CITY OF ALBUQUERQUE

**Re: Murphy Express, Carlisle and Phoenix
Erosion Sediment Control (ESC) Plan
Engineer's Stamp Date 5-31-13 (H16/E008A3)**

**GRADING &
DRAINAGE PLAN**

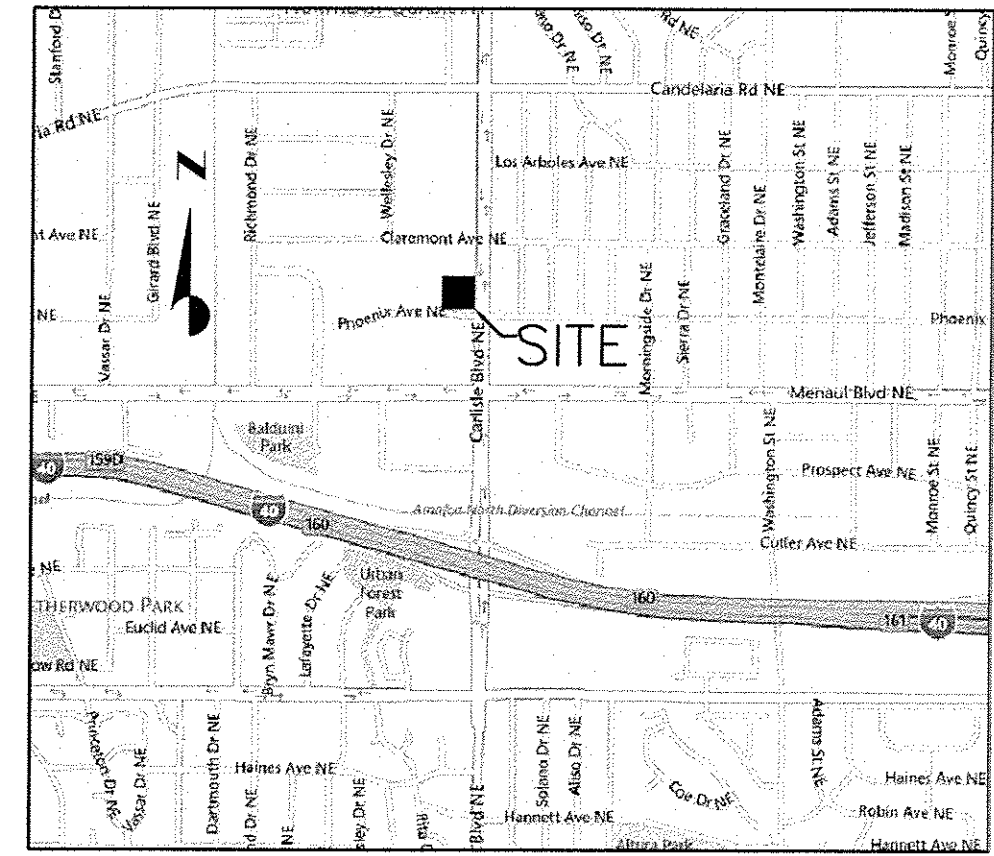
- Please include the north arrow and scale on the plan.
- The silt fence may have to be extended some to the east along the construction fence line at the northeast corner of the project.
- An approved grading and drainage plan will be required prior to an approval of ESC plan.
